CITY OF PORTLAND
DEPARTMENT OF PLANNING & URBAN DEVELOPMENT

Inspection Violations

Owner/Manager EAST DANFORTH LLC		Inspector David Petruccelli	Inspection Date 9/16/2015
Location 67 DANFORTH ST	CBL 040 A022001	Status Follow up Required	Inspection Type Building-Fire Inspection

67/69 BIRD'S EYE VIEW: FIRST FLOOR

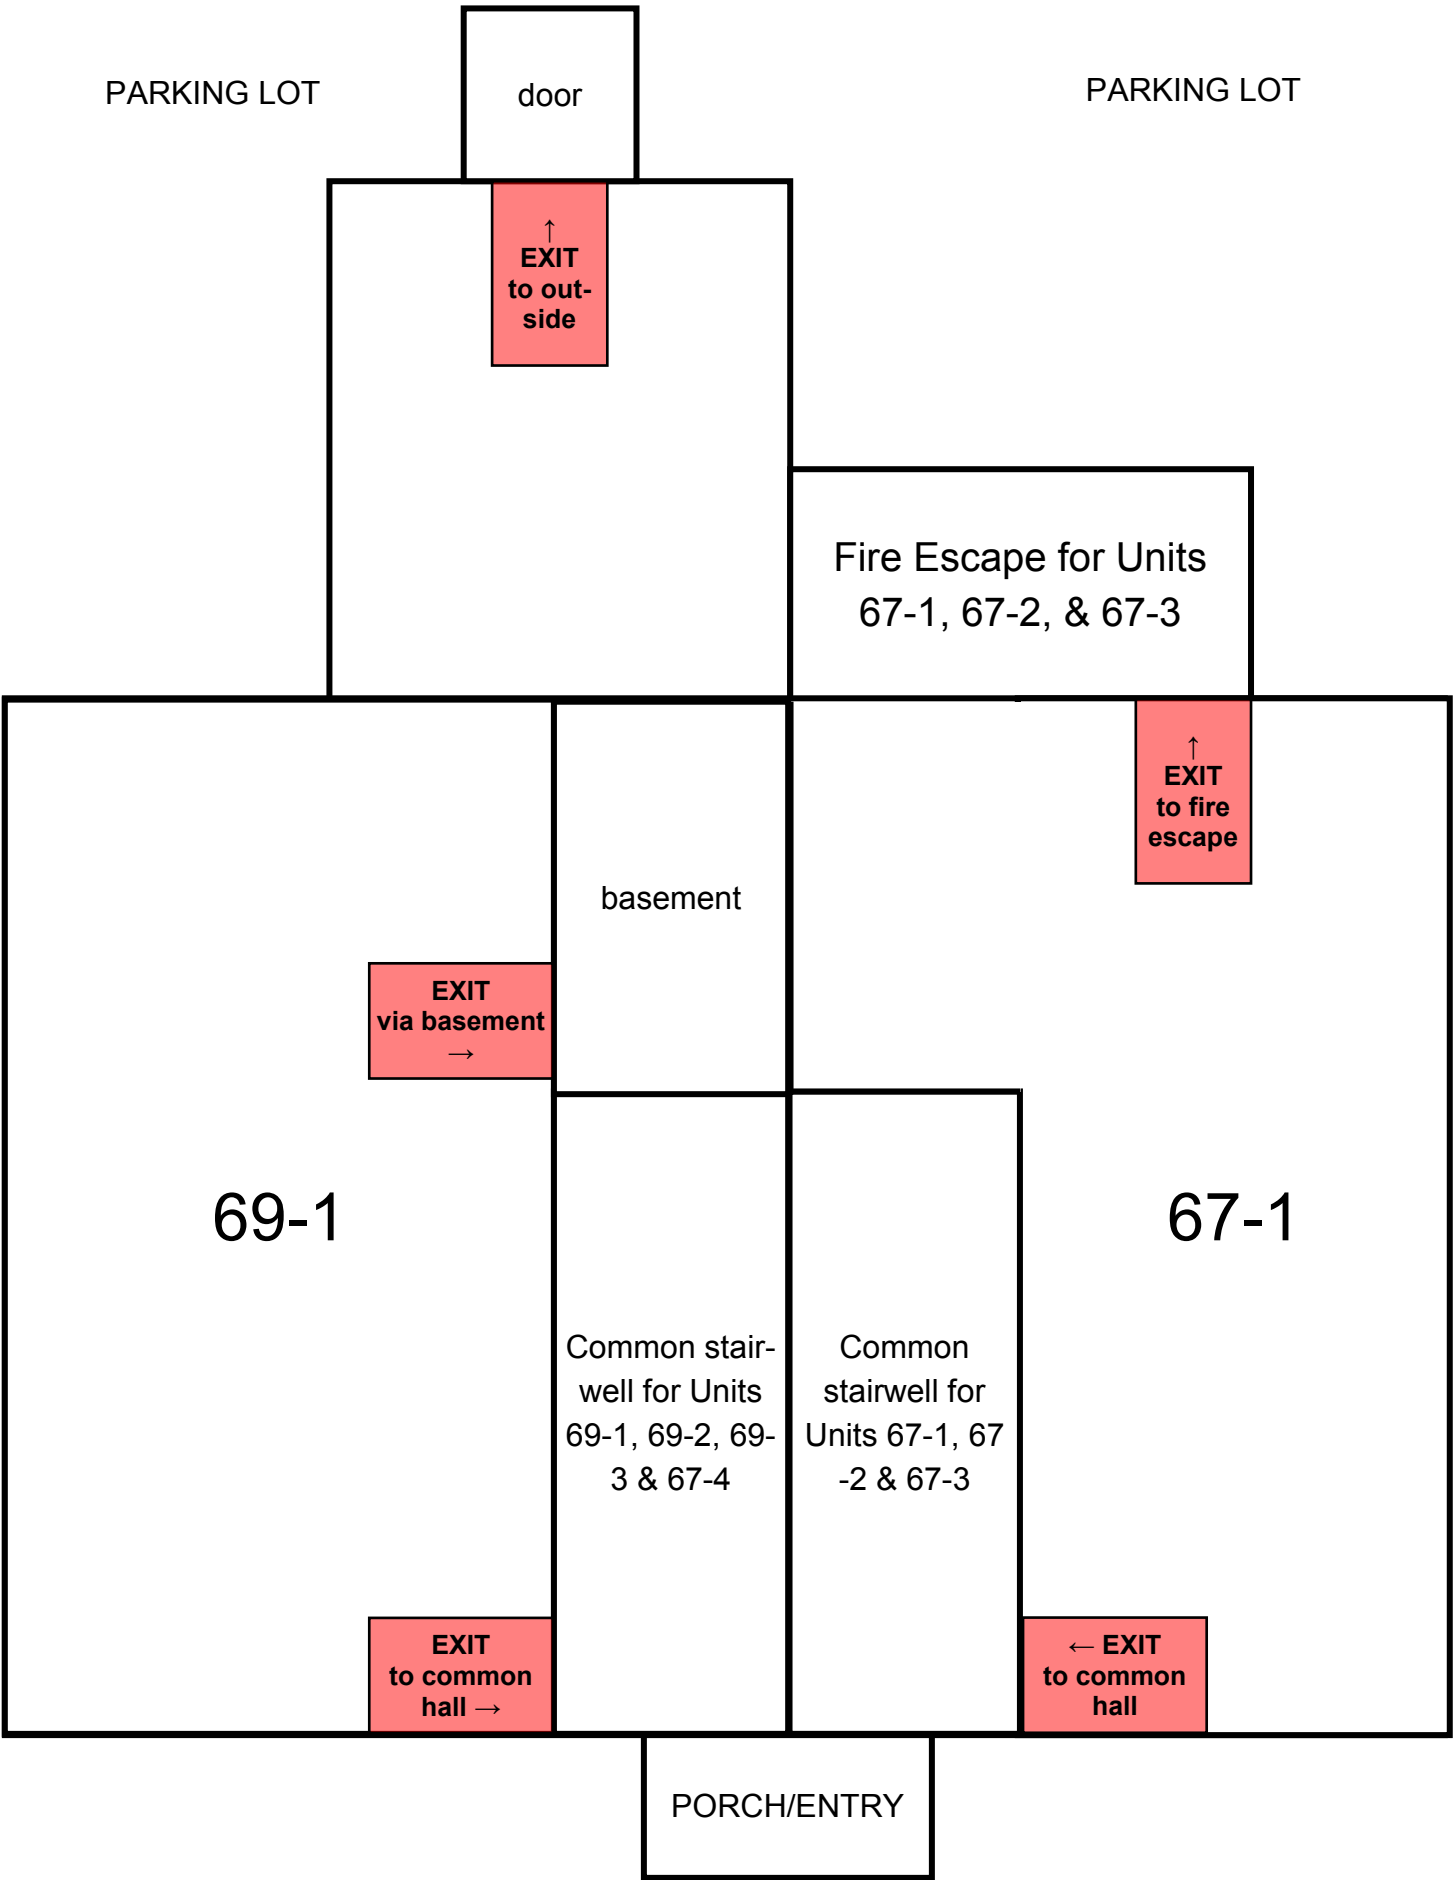
Violation: NFPA 101-7.2.4.3.1 FIRE BARRIER REQUIRES MAINTENANCE; Fire barriers separating buildings or areas between which there are horizontal exits shall have a minimum 2-hour fire resistance rating, unless otherwise provided in 7.2.4.4.1, and shall provide a separation that is continuous to the finished grounded level.

Notes: Basement of 69 Danforth

Violation: NFPA 101- 31.3.3.2 INTERIOR FINISH; INTERIOR WALL AND CEILING FINISH MATERIALS COMPLYING WITH 10.2 SHALL BE PERMITTED AS FOLLOWS:
(1) EXIT ENCLOSURES- CLASS A OR B
(2) LOBBIES AND CORRIDORS- CLASS A OR B
(3) OTHER SPACES- CLASS A, B, OR C.

Notes: Basement of 69 Danforth, exposed foam insulation.

67/69 BIRD'S EYE VIEW: THIRD FLOOR

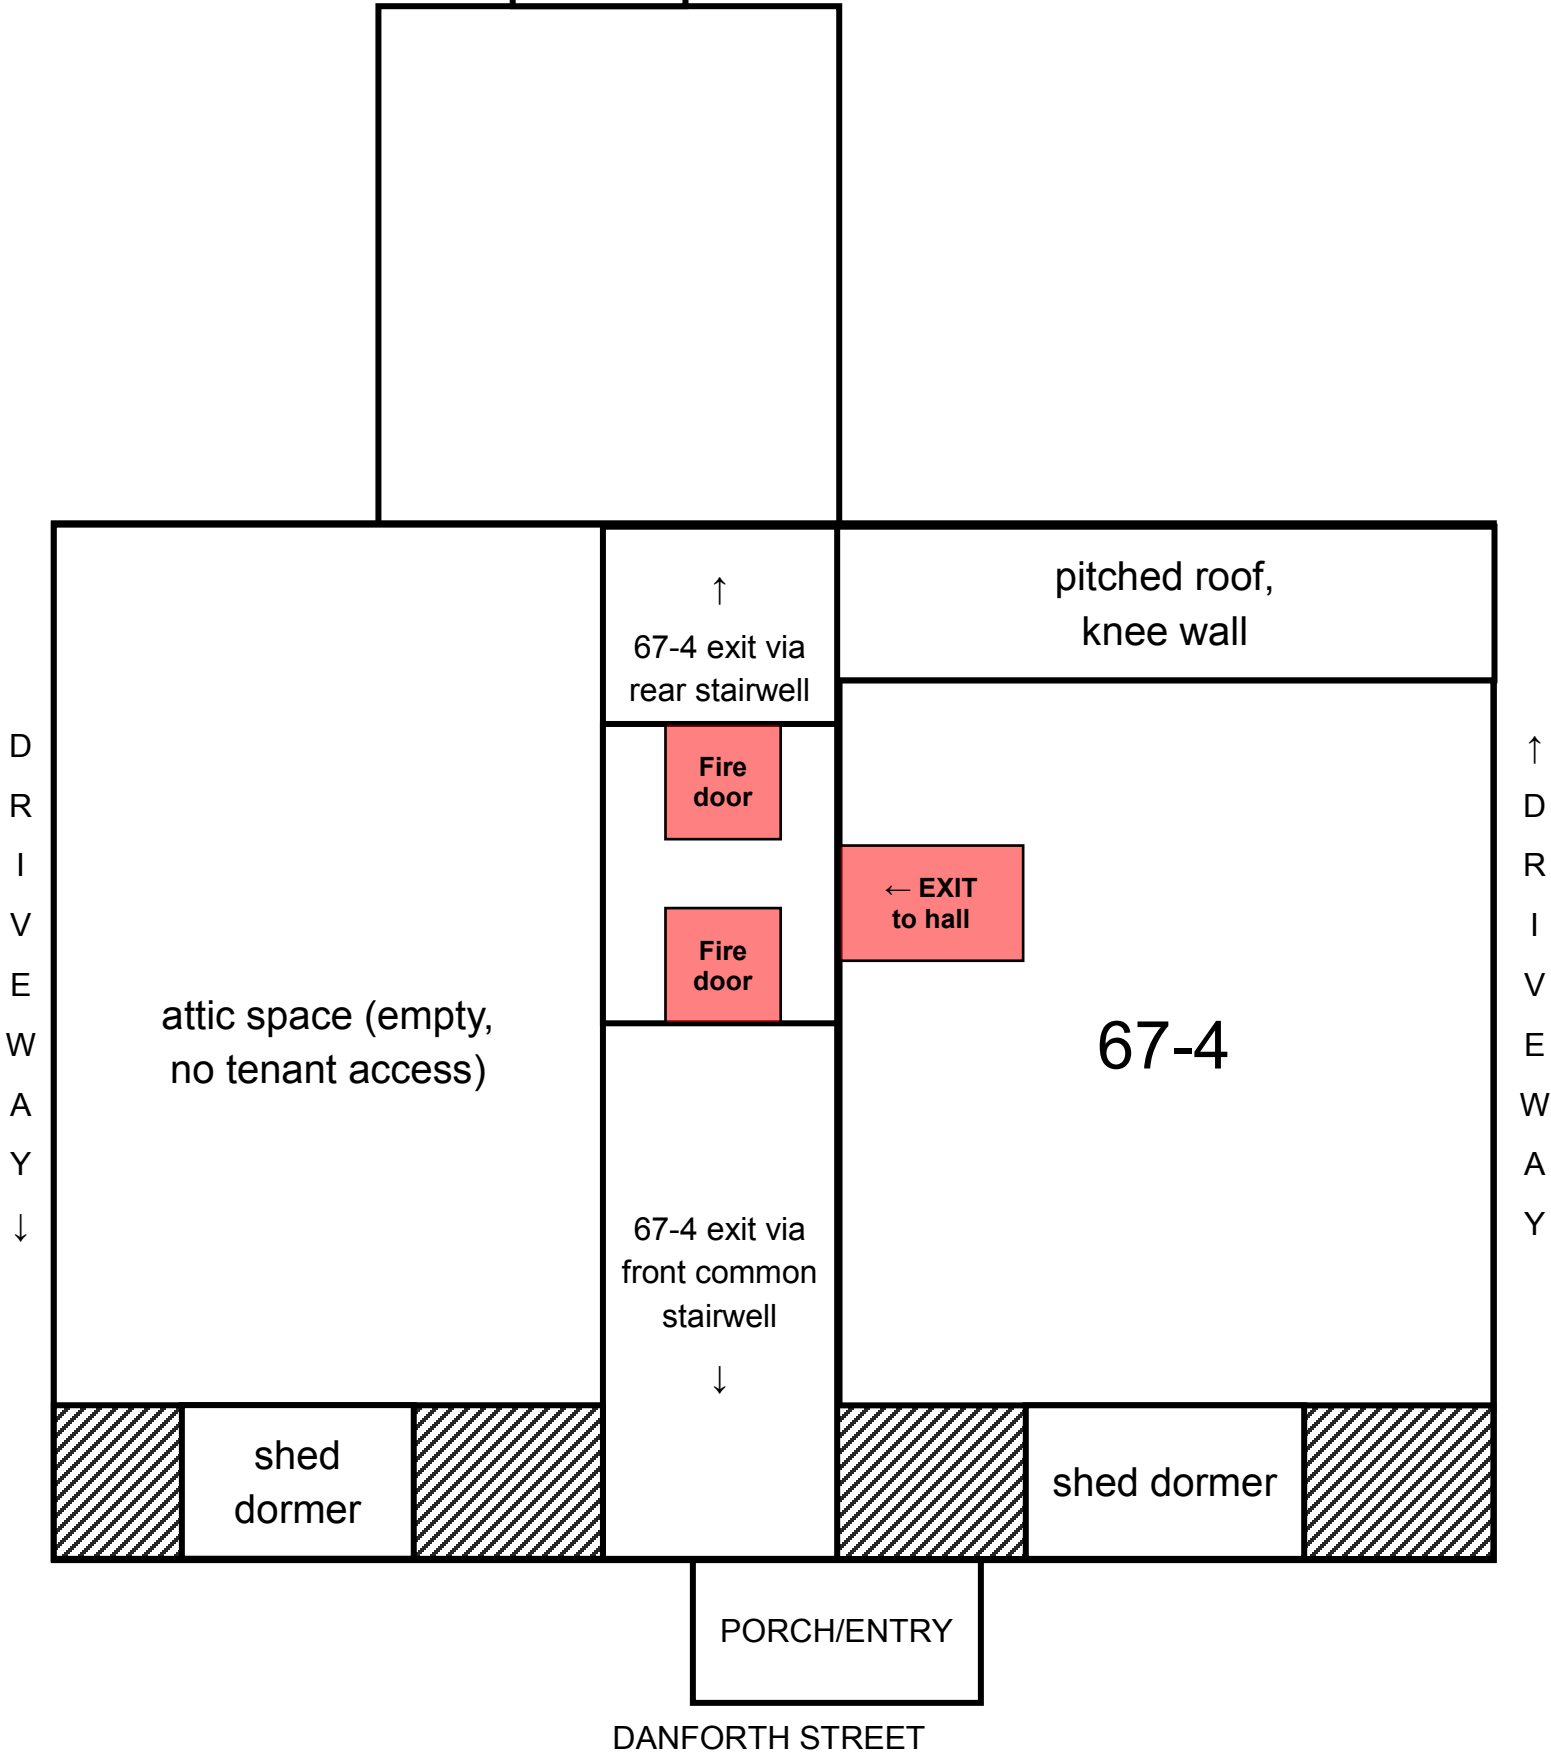
Violation: NFPA 101- 31.3.1.1.1 VERTICAL OPENINGS NOT FIRE RATED; VERTICAL OPENINGS SHALL BE ENCLOSED OR PROTECTED IN ACCORDANCE WITH SECTION 8.6.

Notes: Ceiling 3rd floor of 67 and rear stairwell of 69

67/69 BIRD'S EYE VIEW: FOURTH FLOOR

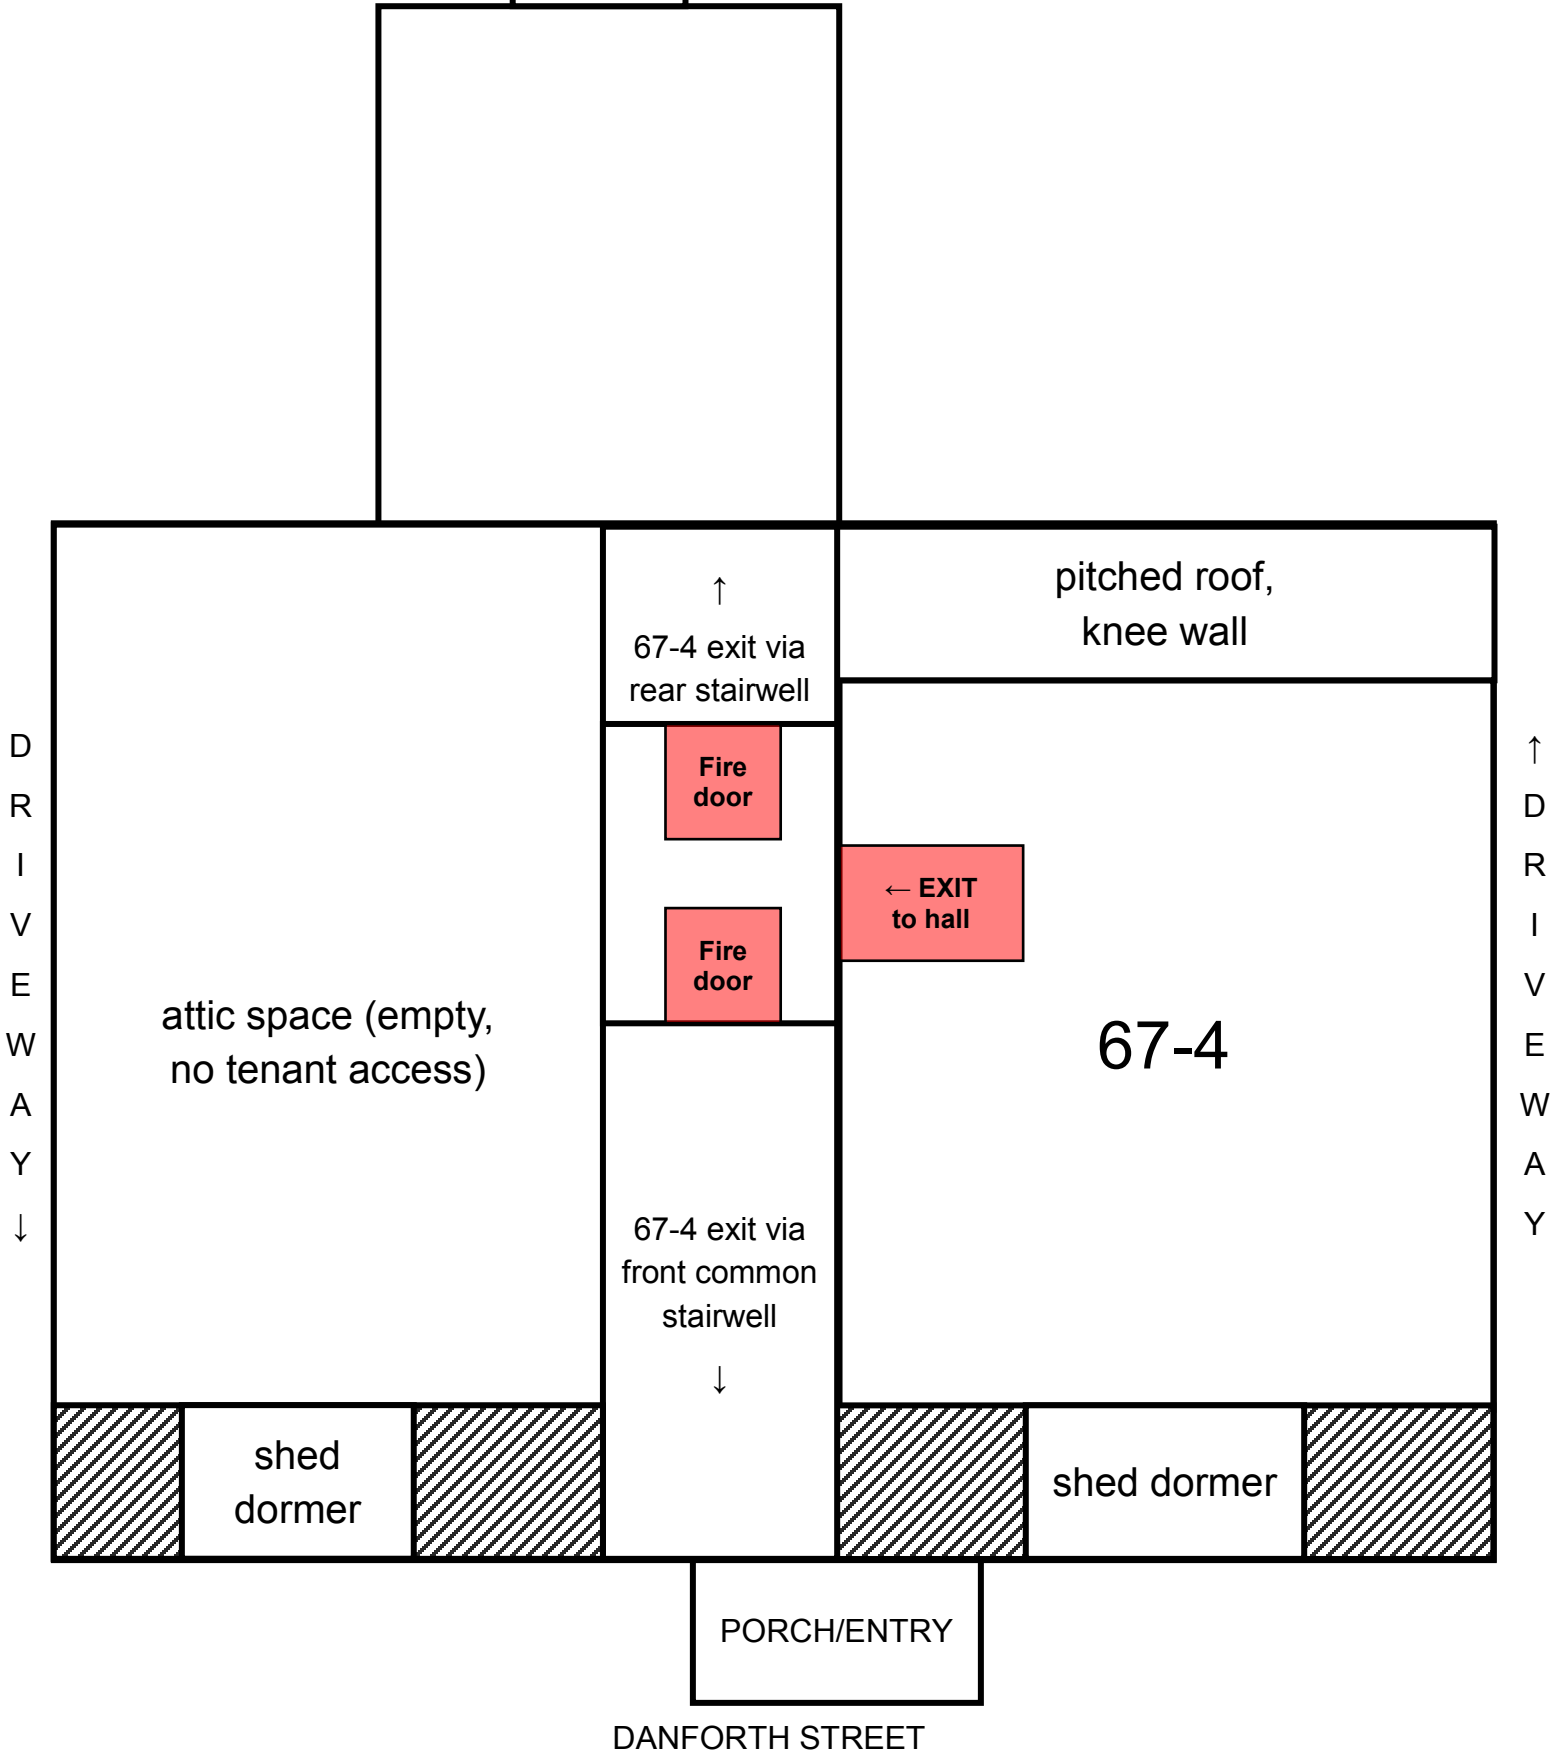
Notes: Rear of units, guide for 67 (unit#4) entry at 69 Danforth

Violation: NFPA 101- 7.2.1.15.8 FIRE DOOR ASSEMBLY REQ REPAIR; DOOR OPENINGS NOT IN PROPER OPERATING CONDITION SHALL BE REPAIRED OR REPLACED WITHOUT DELAY.

Notes: Stair well and unit doors must self close and latch

Violation: NFPA 101- 7.2.1.8.1 FIRE DOORS MUST BE SELF- OR AUTO-CLOSING; A door leaf normally required to be kept closed shall not be secured in the open position at any time and shall be self-closing or automatic-closing in accordance with 7.2.1.8.2, unless otherwise permitted by 7.2.1.8.3.

Notes: Various units and 3rd floor landing

Violation: NFPA 101- 7.2.1.8.1 FIRE DOOR BLOCKED OPEN; A door leaf normally required to be kept closed shall not be secured in the open position at any time and shall be self-closing or automatic-closing in accordance with 7.2.1.8.2, unless otherwise permitted by 7.2.1.8.3.

Notes: Both doors at 3rd floor landing
